MEMORANDUM

TO: Barbara Barhydt, Development Review Services Manager
FROM: David Senus, PE
DATE: April 1, 2015
RE: Riverside Industrial Parkway Unutil Facility, Administrative Authorization

Woodard & Curran has reviewed the Administrative Authorization Application for the proposed Unutil Facility located at 376 Riverside Industrial Parkway in Portland, Maine. The project involves site improvements for an existing facility.

TYPICAL CATCH BASIN

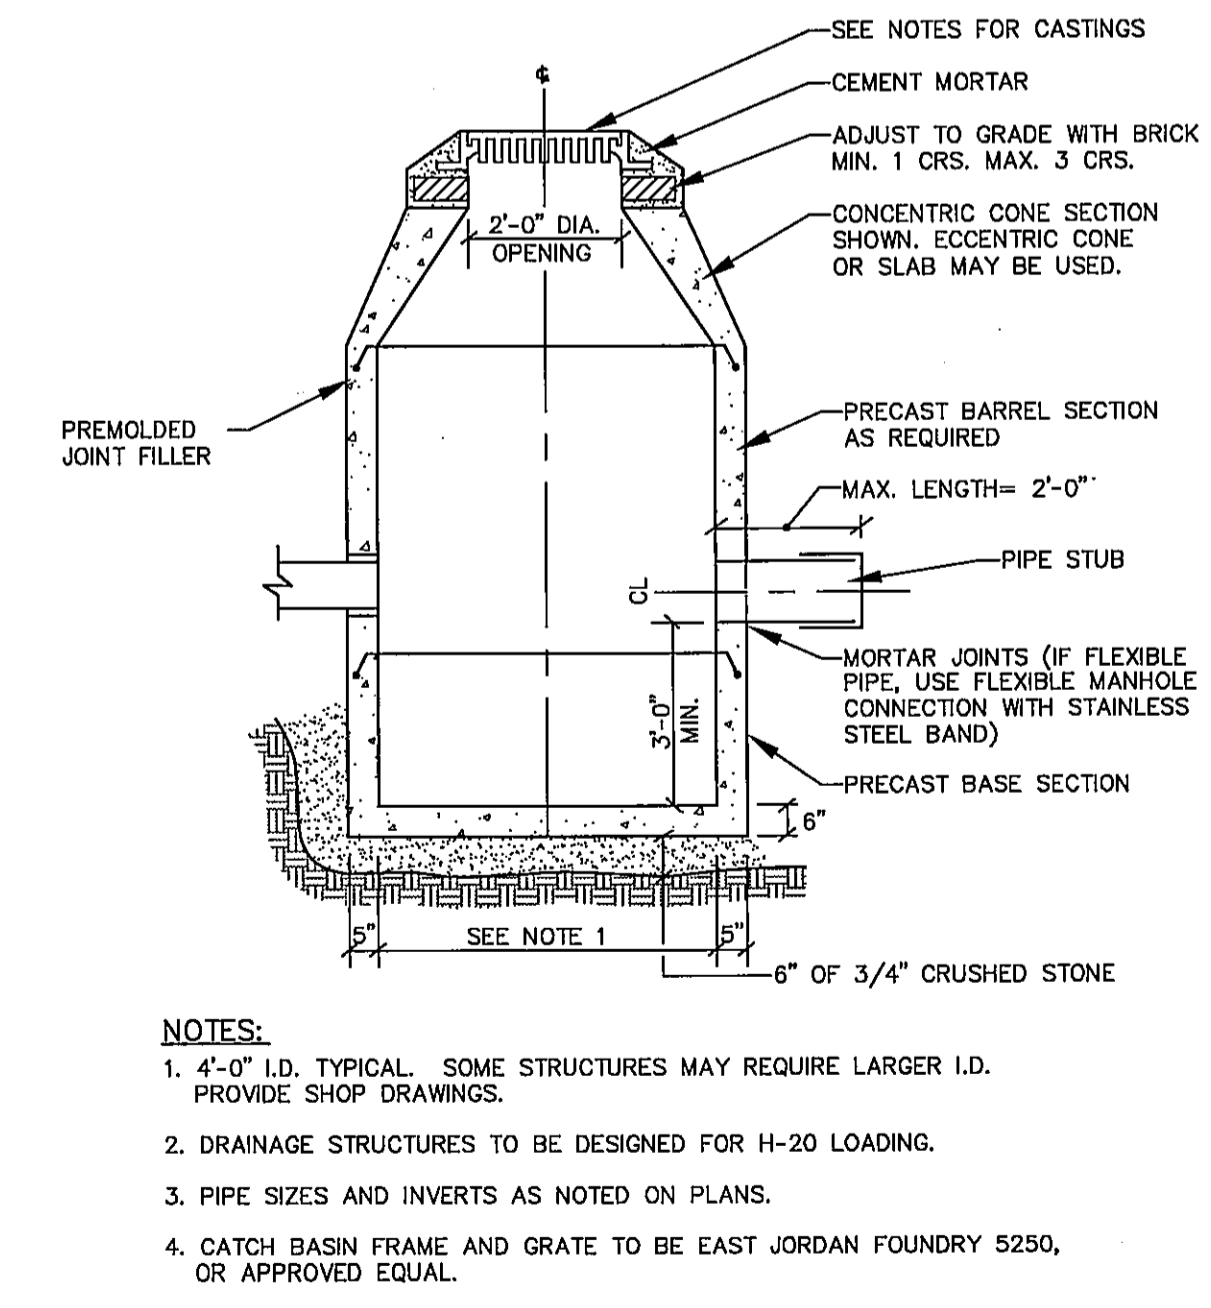
- 1) The Applicant should provide notes and details for catch basin inlet protection devices and silt fencing to protect catch basin inlets and the site's pond from potential sedimentation from the proposed site work.
- 2) The Applicant should provide a detail for the trench work associated with the proposed electrical conduits.
